From: Nicola Swann [REDACTED]
Sent: 28 November 2018 09:27
To: Planning.Responses
Subject: Pagham responses

6.1 P/105/18/HH – 14 Sea Lane Pagham PO21 4UL – Rear single storey extension.

sheet 2 of 3

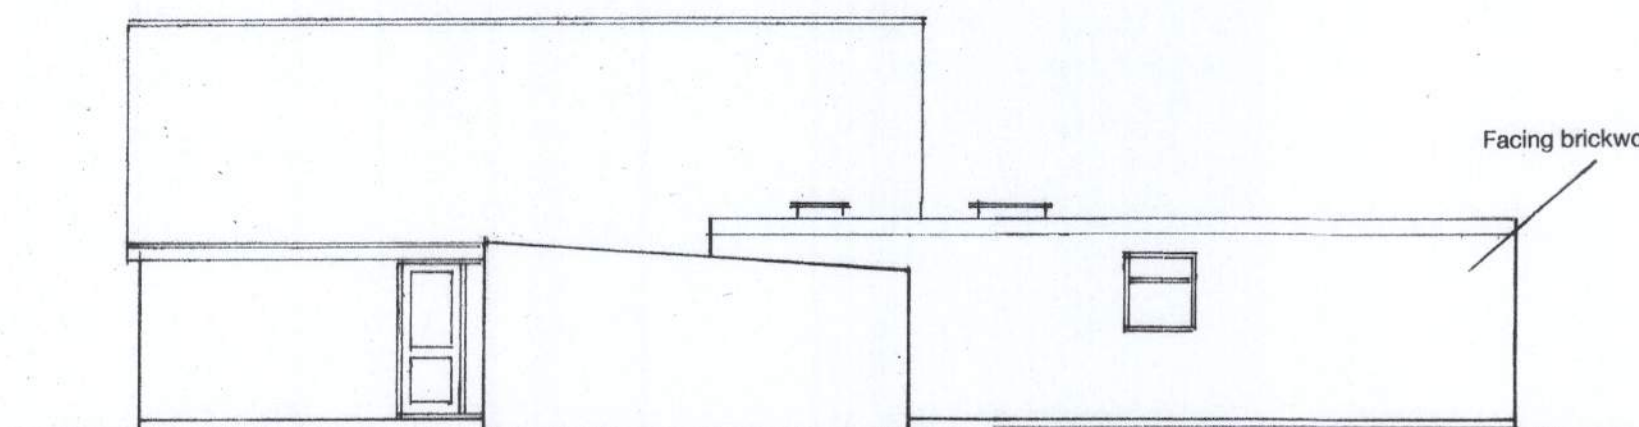
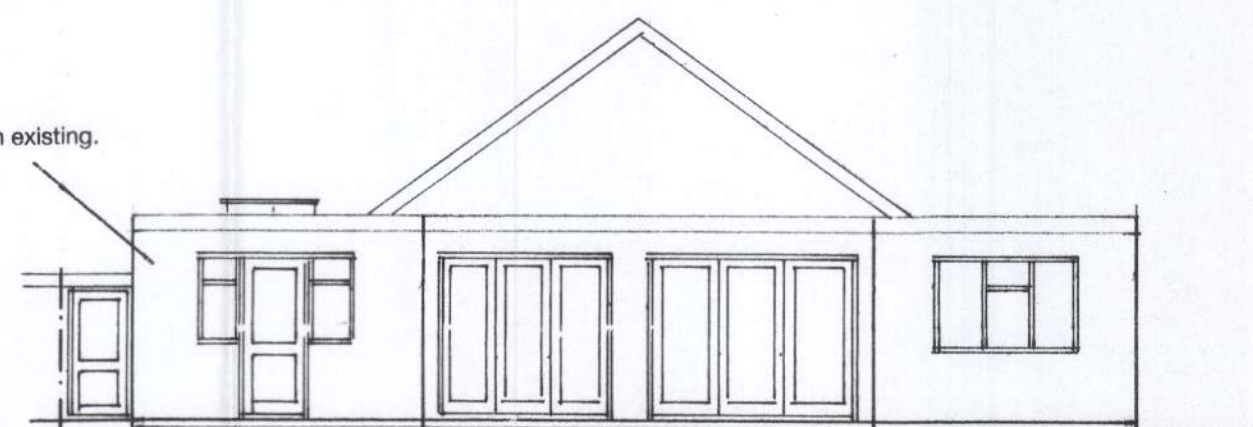
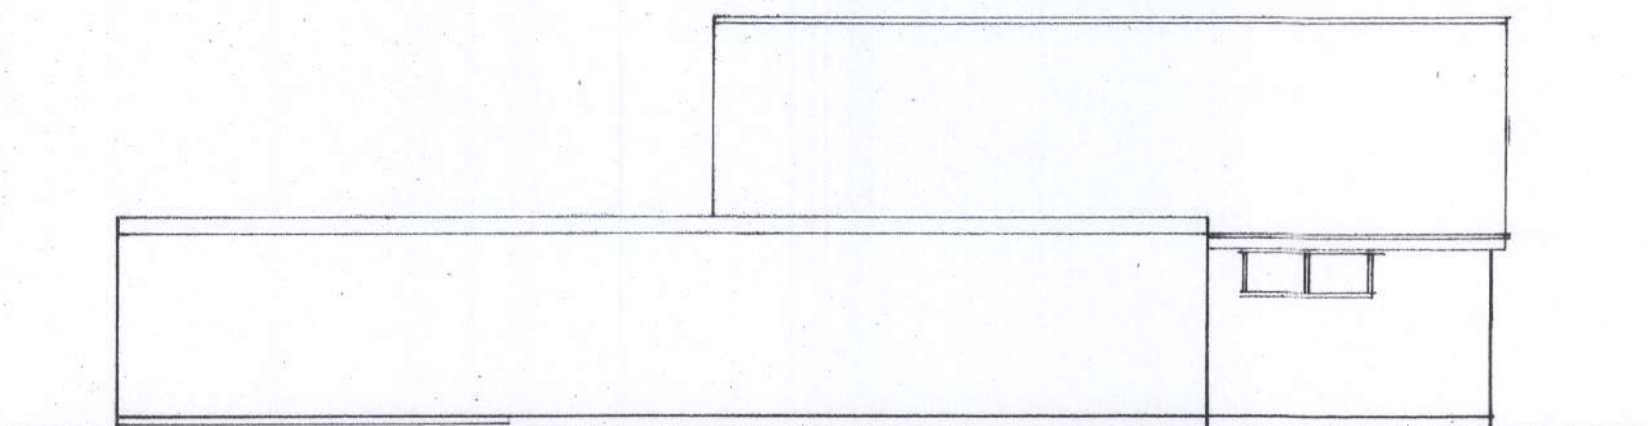
RESOLVED: NO OBJECTION however the Council raised concern regarding the rear window looking towards the neighbouring property. It would wish to see a condition requiring obscure glazing to protect privacy.
